Inspector's Addendum Report ABP-320049-24

Construct 267 residential units, a childcare facility, a link road, road upgrades along the Old Navan Road (R157) and associated development

Bennetstown, Pace & Dunboyne townlands, Dunboyne, County Meath

01 Ground Floor Plan
1:100 @ A1

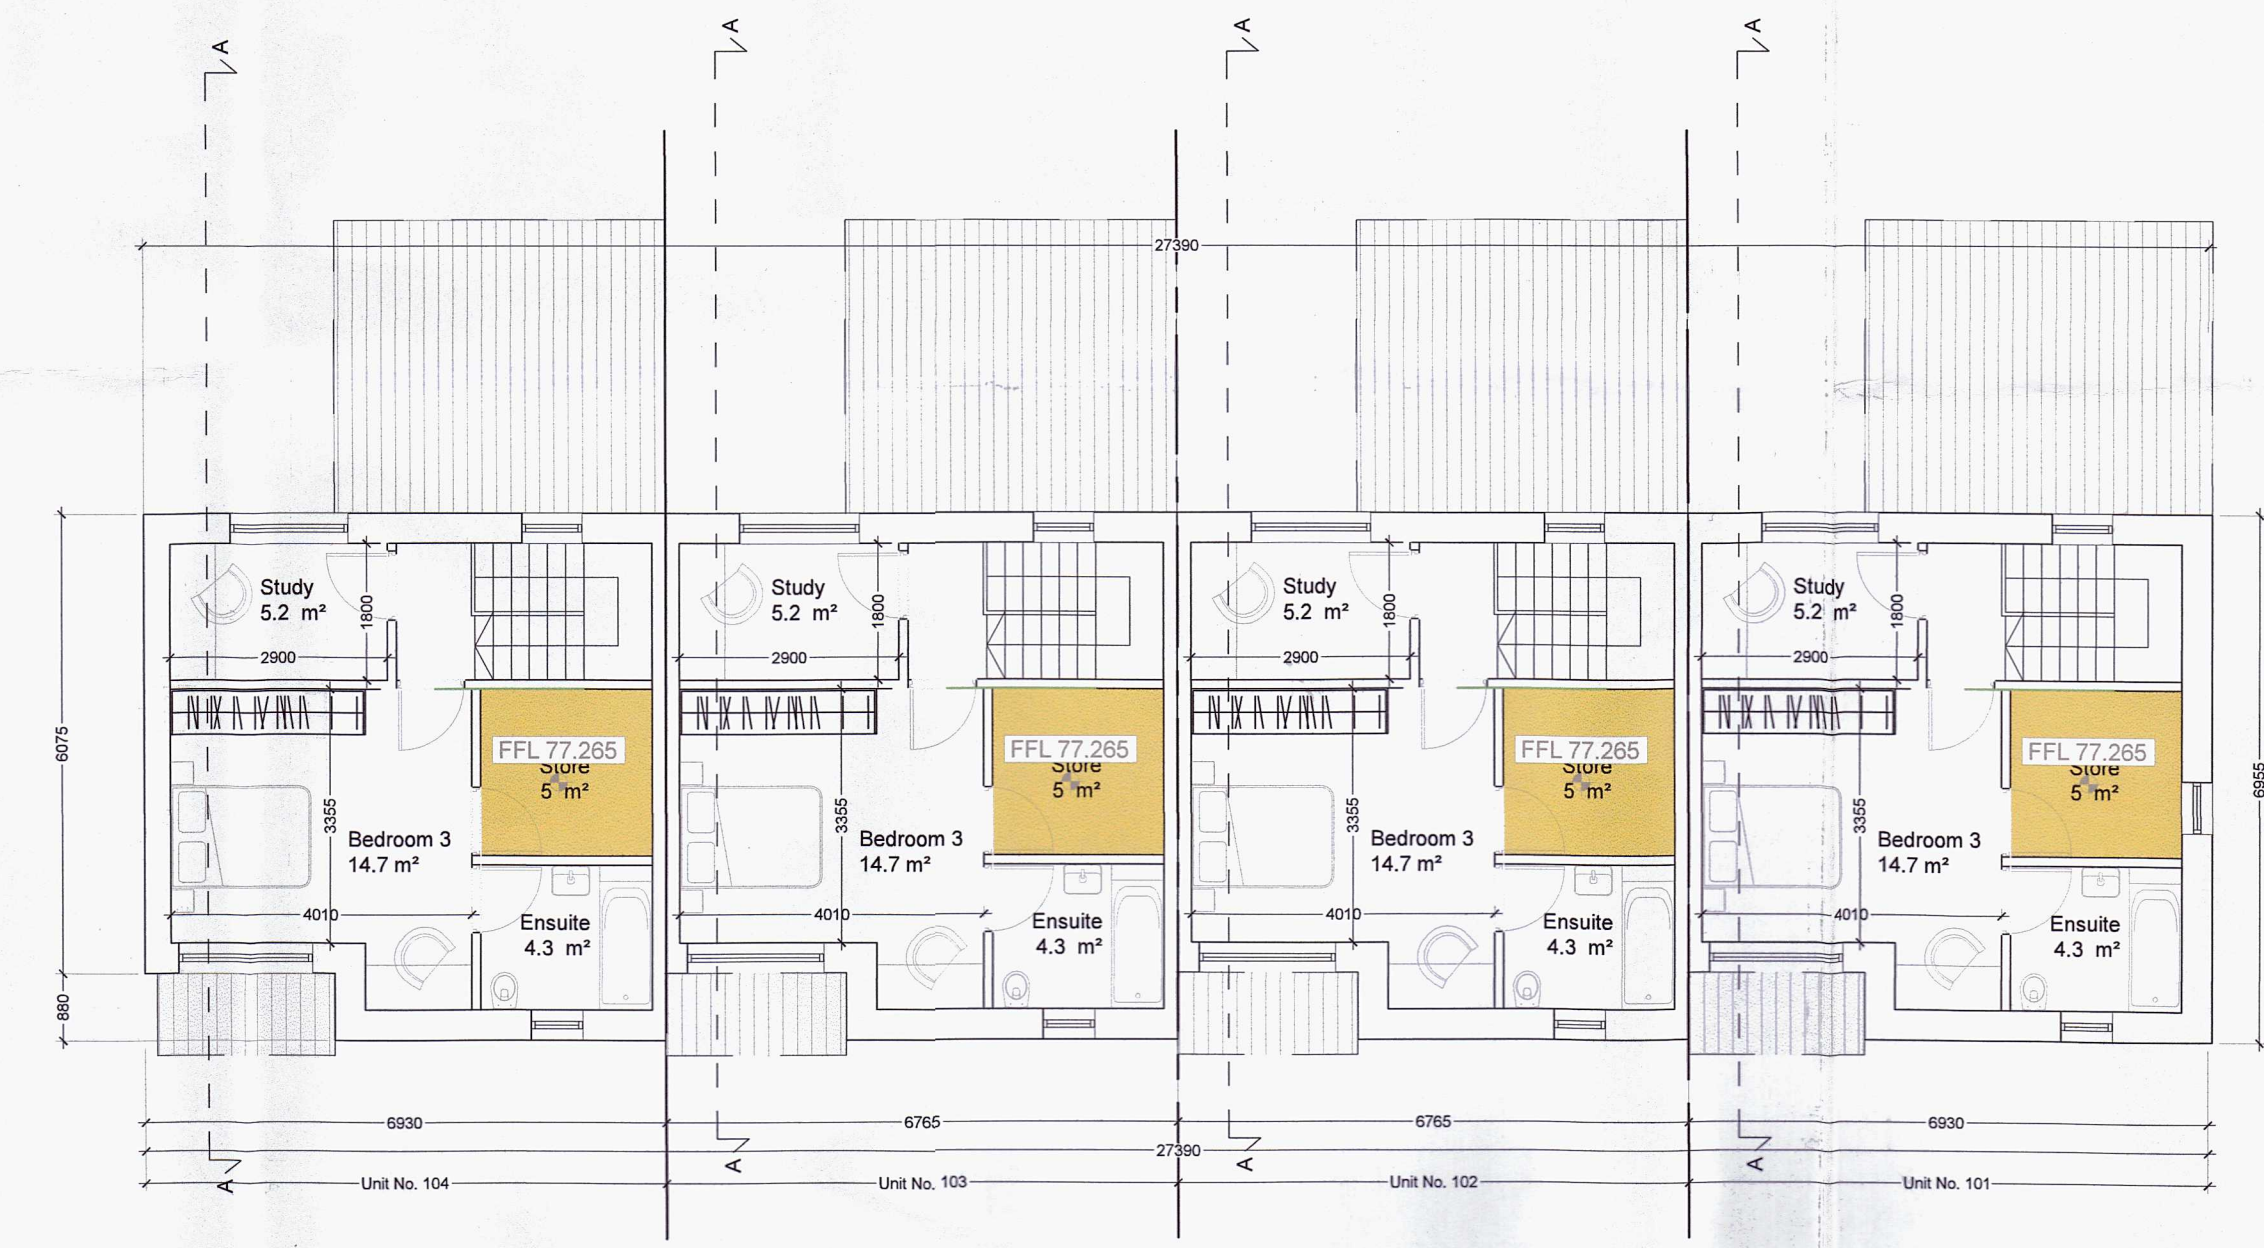
- 2.6.7. Consequently, with the exception of block G, integrated accessible communal space could be provided for the subject blocks in line with the provisions in SPPR 2 of the Guidelines. As noted, the minimum reduced provision of 20sq.m private open space for the subject townhouses would not be provided based on the plans presented in the application. Notwithstanding this, there would be scope for an additional 4.7sq.m of terrace or patio areas to be provided directly adjoining the rear of these units given their context and layout, with doorways opening directly onto these areas as part of the first-party's ground floor plans for the subject townhouses. With the provision of such terrace / patio areas, the proposals would align with the approach within the Guidelines to the provide innovative housing solutions, while also ensuring the townhouses in blocks D, E and F could comply with SPPR 2 of the Guidelines.

- 2.6.9. Given the layout constraints in providing directly accessible high-quality and integrated communal space for each of the four townhouses in block G, the proposed development would not achieve the necessary private amenity space standards for this block in line with SPPR 2 of the Guidelines. Accordingly, in the event of a grant of planning permission, I am satisfied that a condition should be attached omitting block G from the proposed development. It would appear most logical from a planning perspective for the resultant area arising from the omission of block G to be absorbed into the adjoining public open space serving neighbourhood cell E. The omission of block G would result in the development achieving a net density of 51 units per hectare, which would remain in line with Development Plan and National planning policy provisions.

4. The proposed development shall provide for a total of 263 residential units and shall be amended as follows:
 - (a) block G, including the private open space and communal space proposed to be associated with this block, shall be omitted from the proposed development, and the resultant area shall be landscaped as public open space and integrated with the adjoining public open space serving neighbourhood cell E of the proposed development;
